DEVIATION REQUEST AND DECISION FORM

Project Name : Eagleview Subdivision
 Rule No.(s) : 5226000001, 5226000001
 Description : N2NW4 EX WLY 620.0 FT SEC 26-12-65,S2NW4 EX WLY 620.0 FT SEC 26-12-65

LSC Response to EPC PCD deviation 1 comments

LSC Responses to EPC PCD deviation 2 comments 1

# Deviation No. 3\*

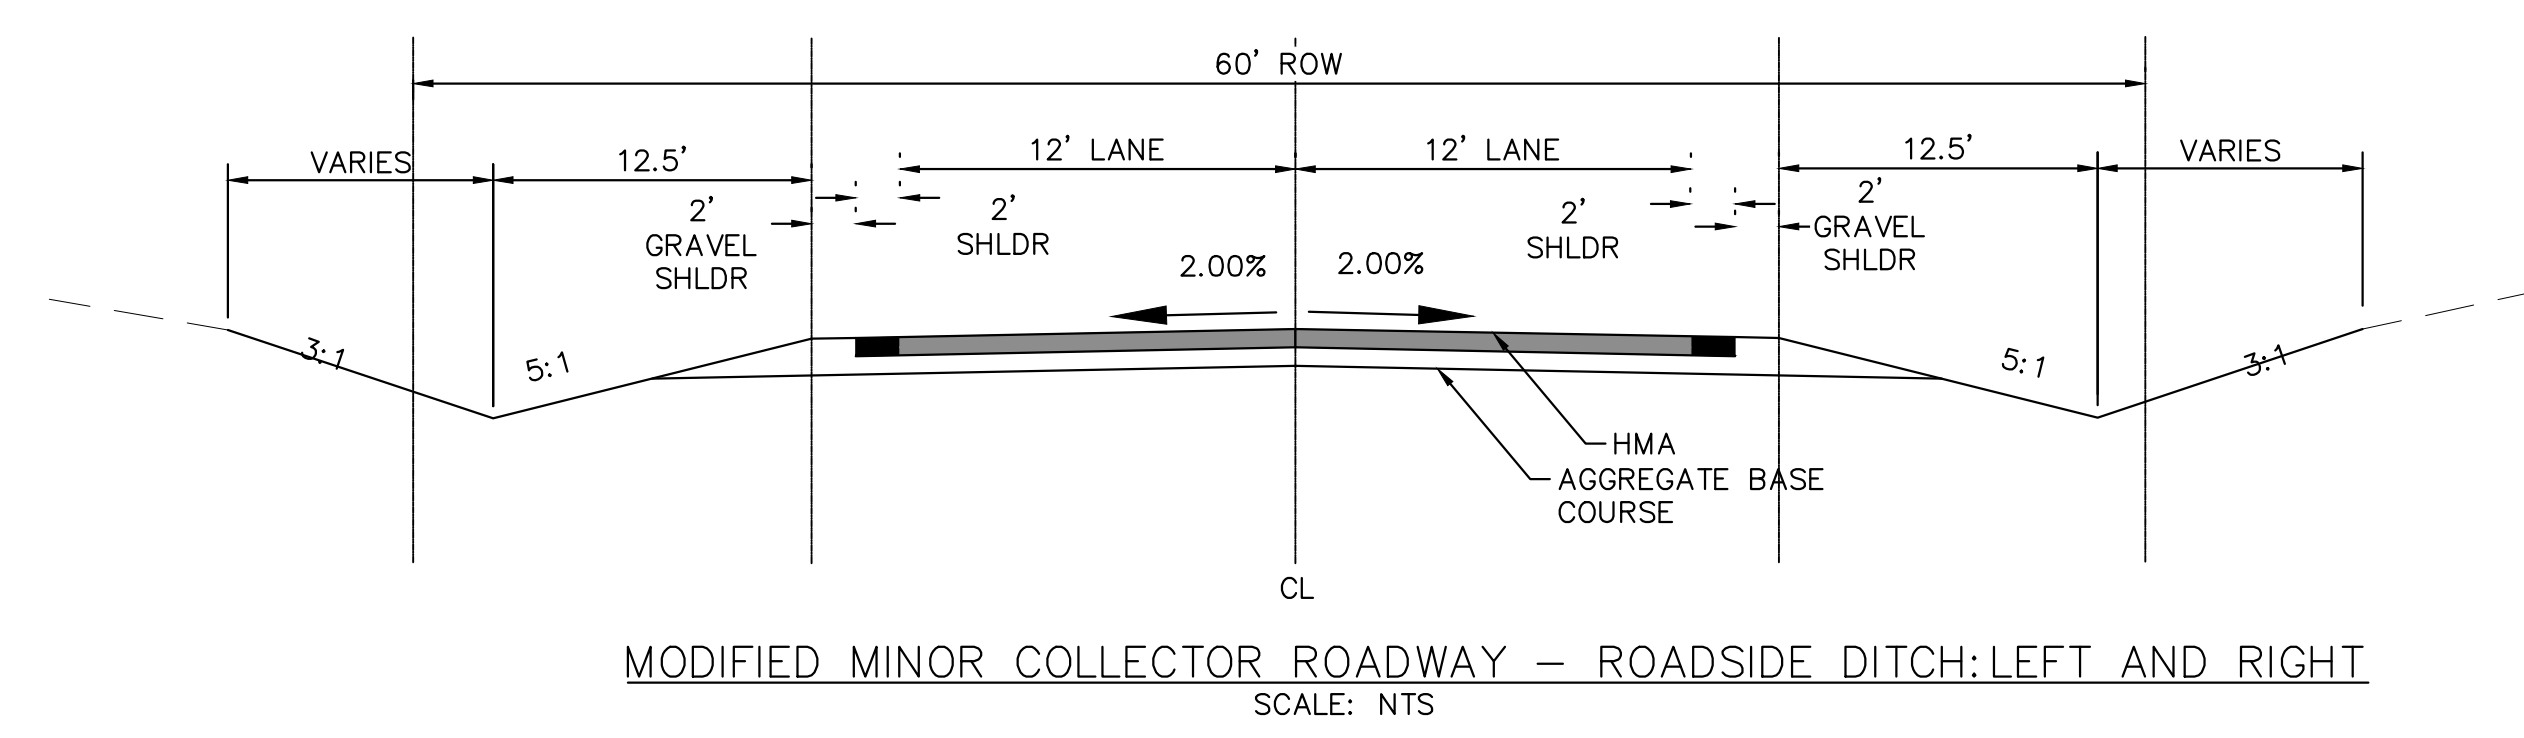
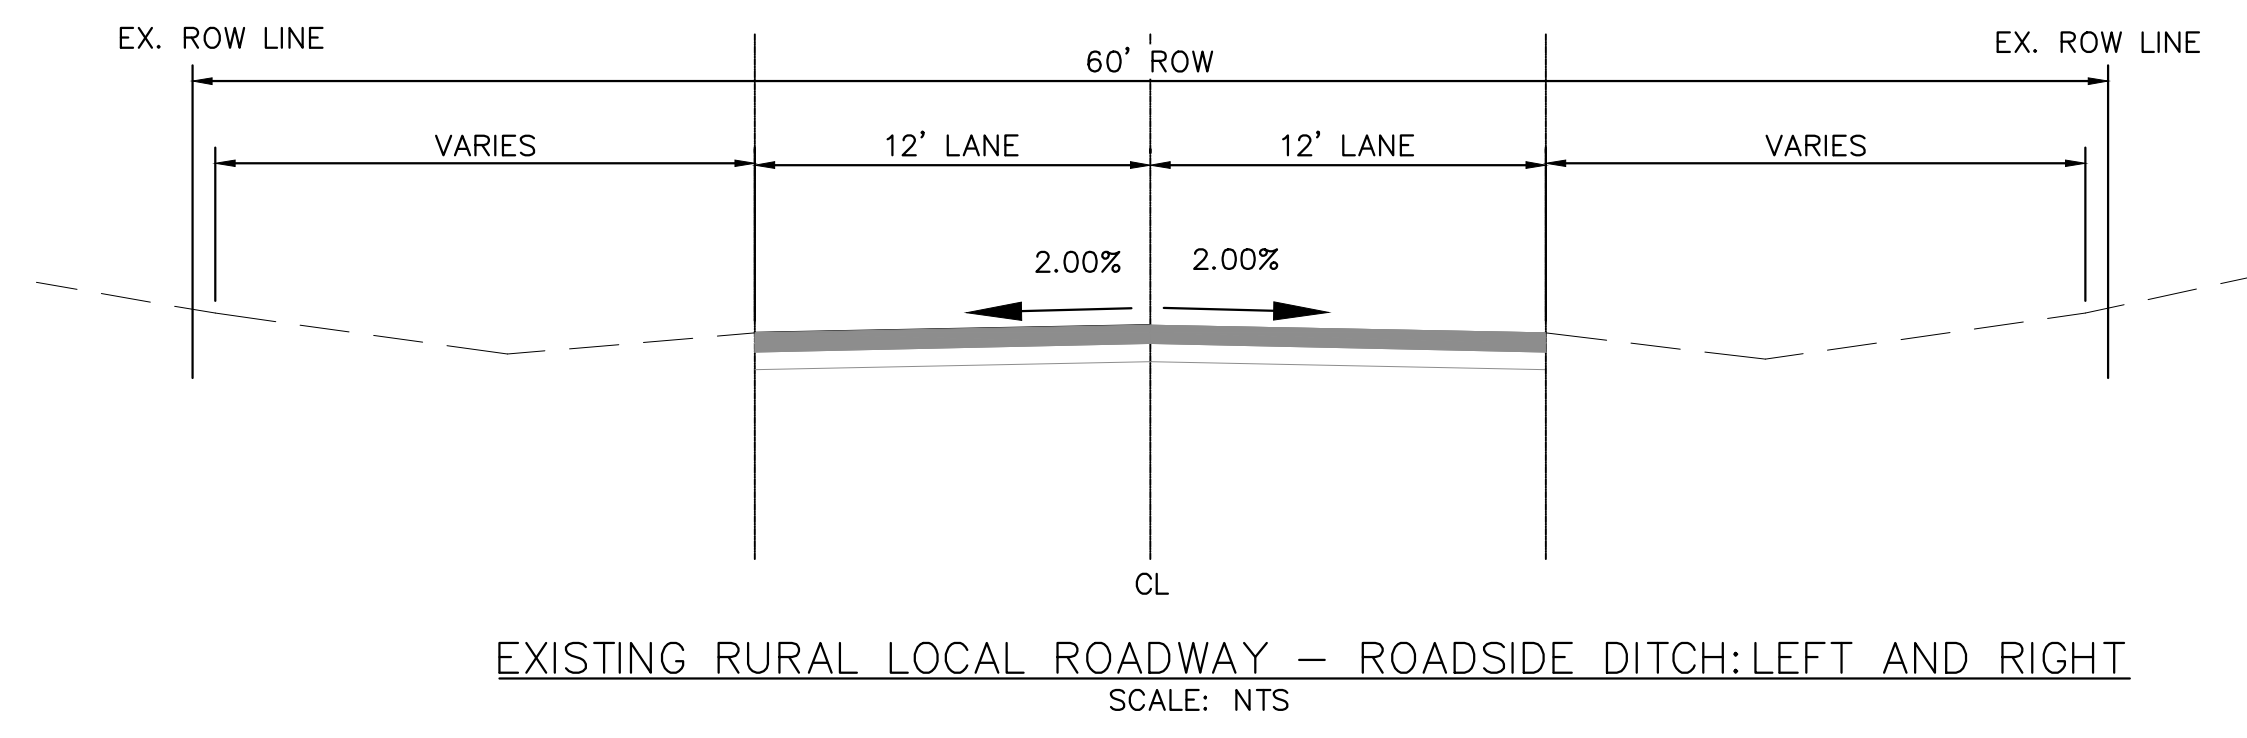
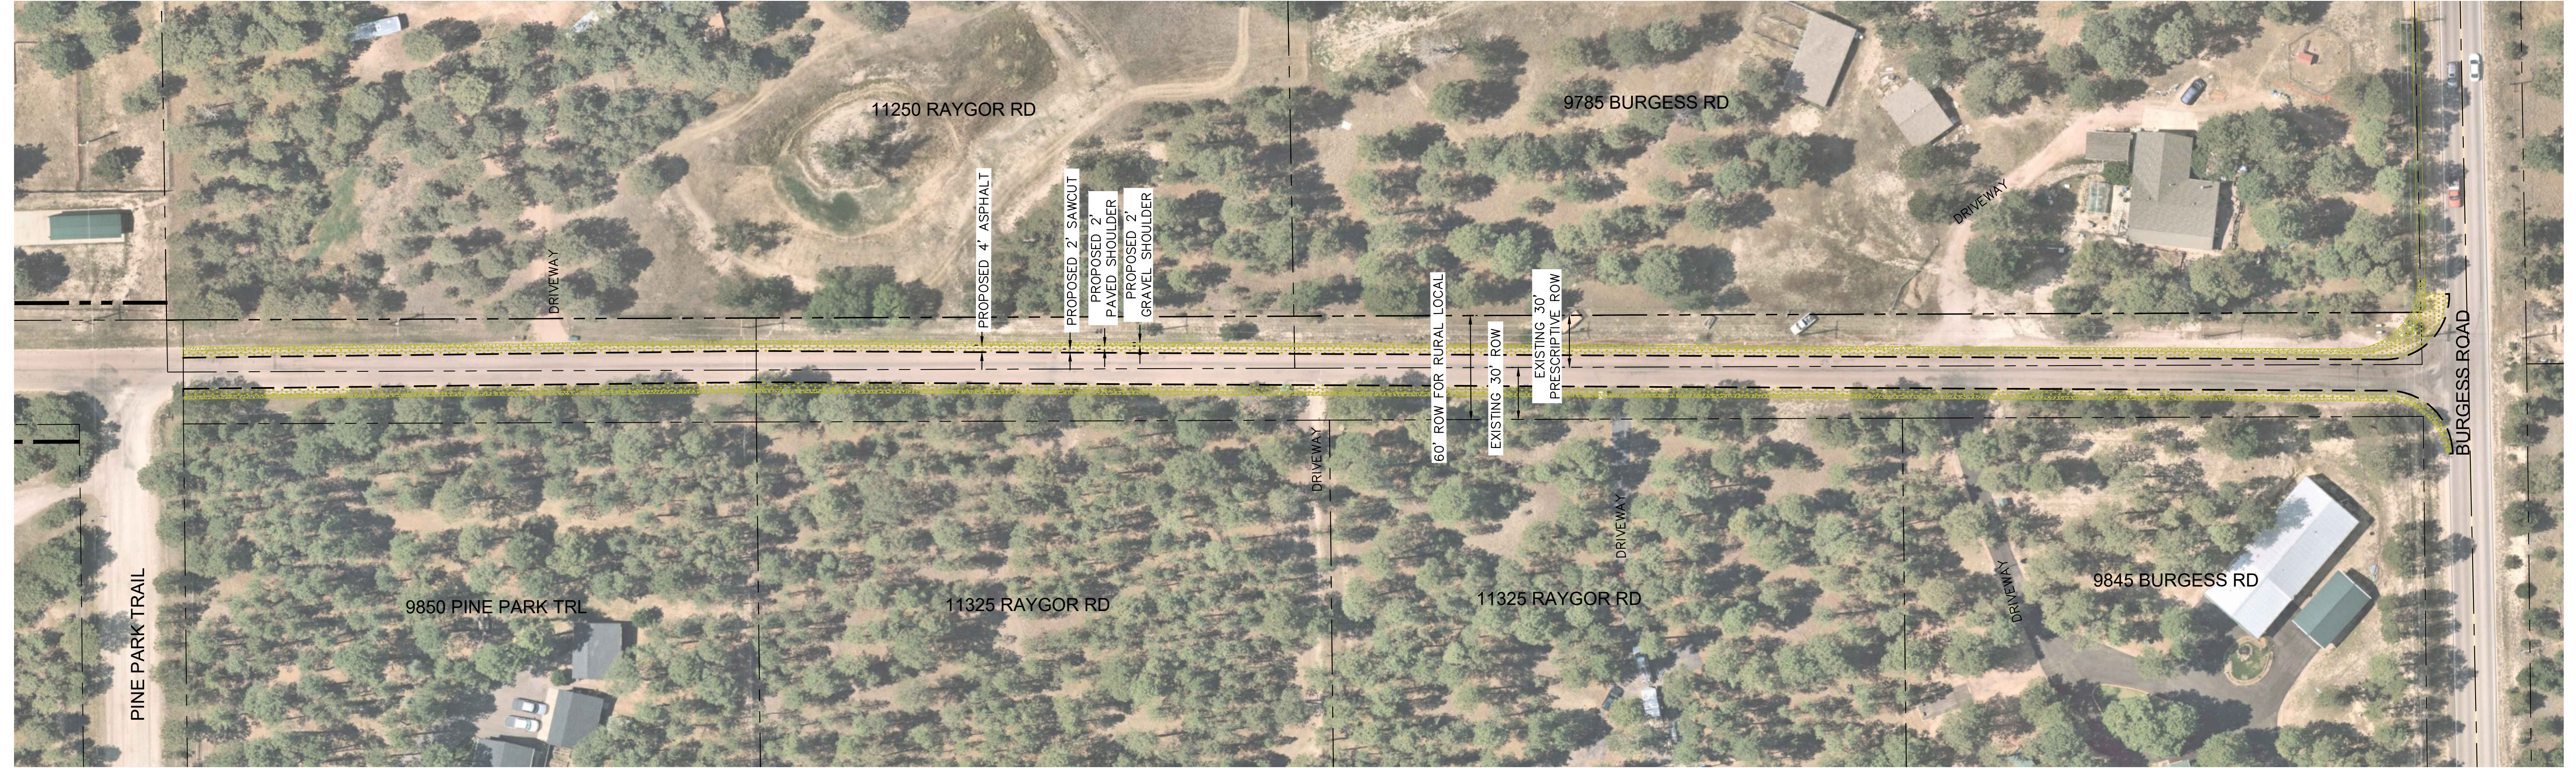
Doing nothing is unlikely to be approved. An alternative must be explored. One potential may be to obtain property from PBH14 to connect to their road network. This may divert sufficient traffic that the ADT is no longer exceeded. The previous preliminary plan identified a fair share participation or escrow, see preliminary plan condition number 8

LSC Response: The applicant is now proposing an alternative. Please refer to the updated deviation request.
